Planning Application K/19/22/HH re Flint Barn, Peak Lane, Kingston BN16 1RN

Kingston Parish Council makes the following comments re this application:

PROPOSED FLOOR PLAN + ELEVATIONS

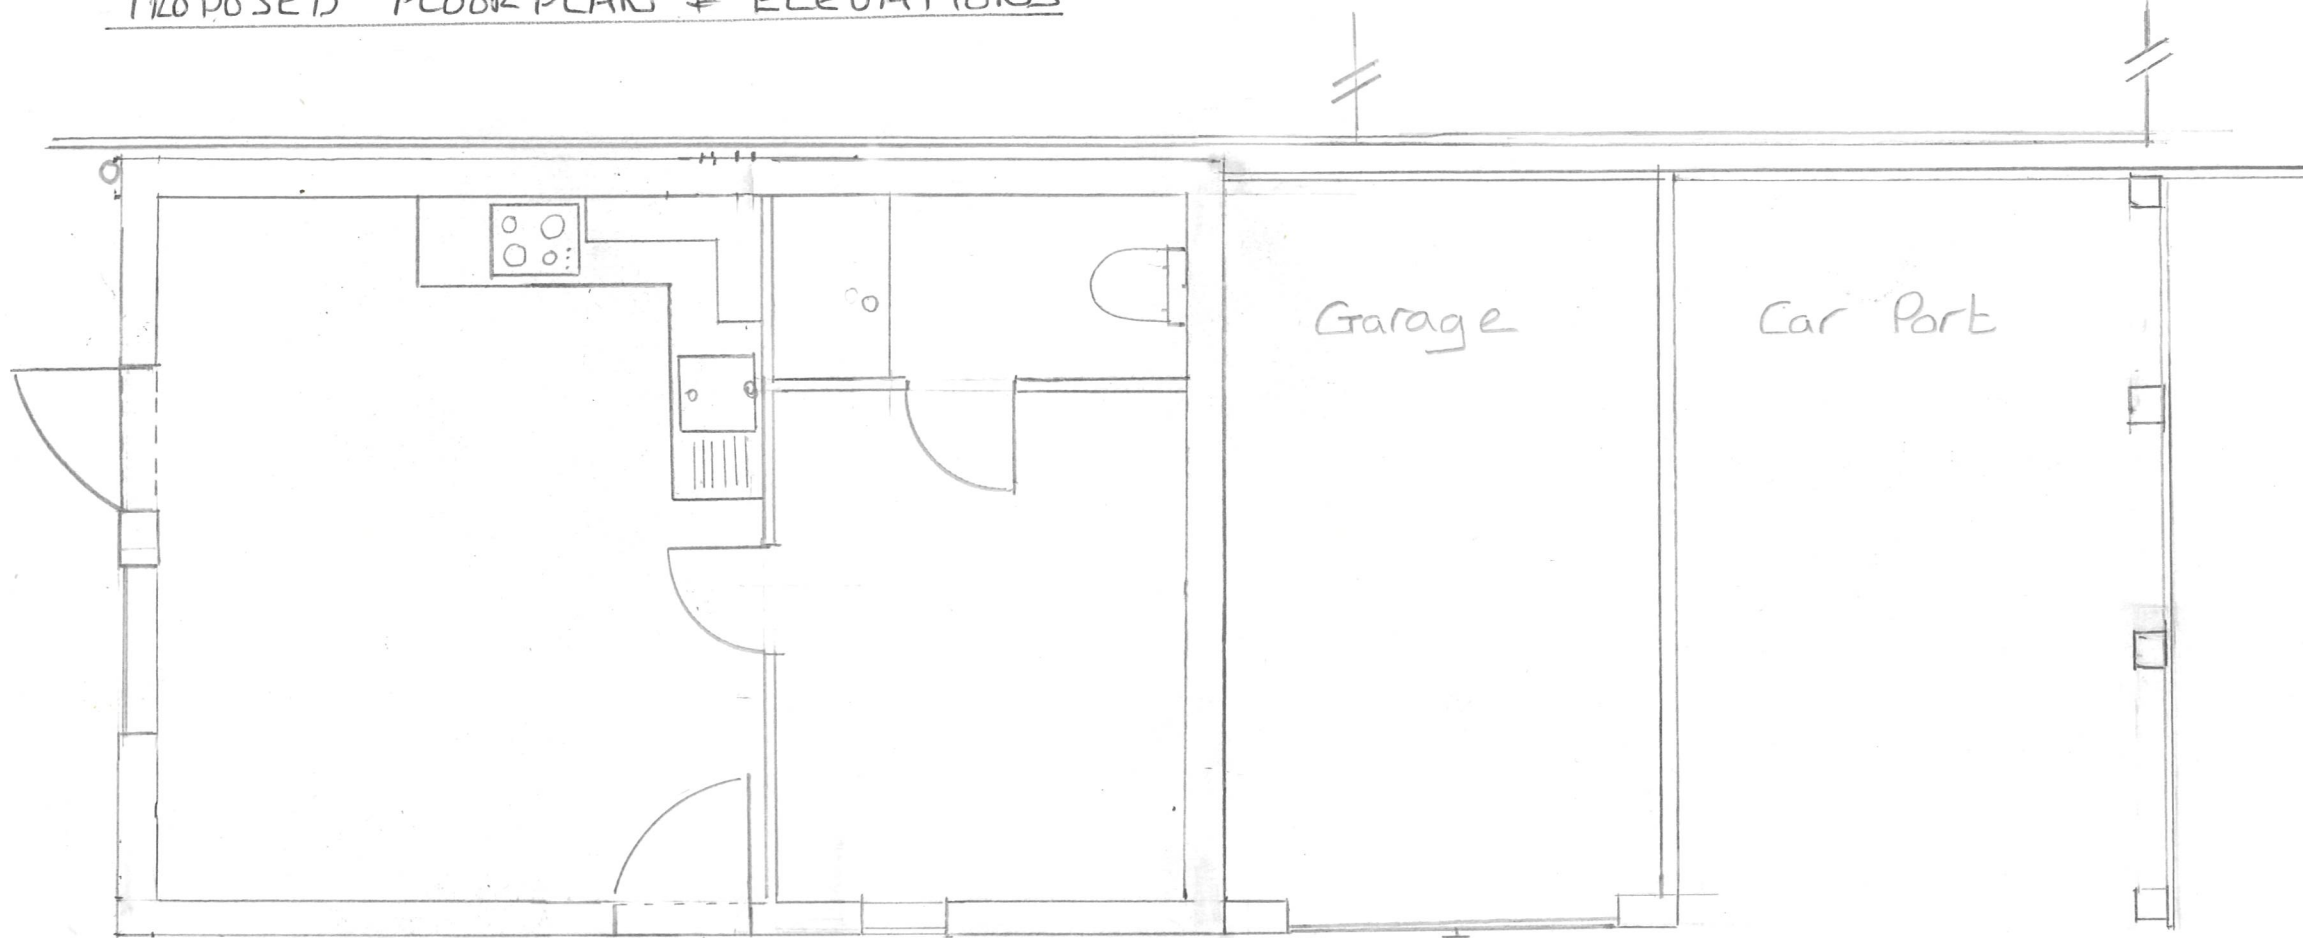
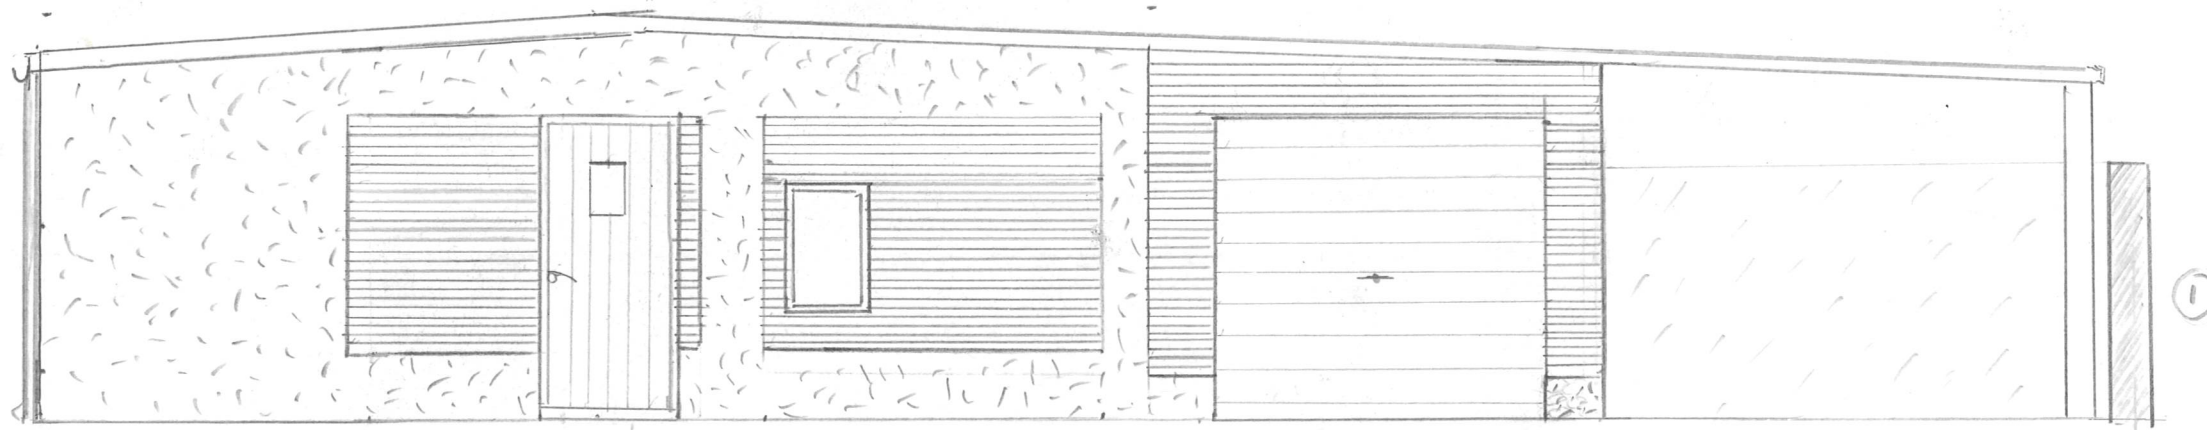
2. Allowing the double garage that is used as a hobbies room to become a fully habitable space with full services because of its location on the plot and future usage will adversely affect the amenity of neighbouring properties. It is particularly close to the living rooms of The Moorings
3. The property is outside of the Built-Up Area Boundary and in the Gap between Settlements. The addition of an extra garage so close to the boundary with other properties will impact on the density of dwellings in this area of countryside
4. If the Planning Officer is minded to approve this application it should only be for ancillary use to the main dwelling and the plot it applies to should be clearly defined (i.e. the original double garage).
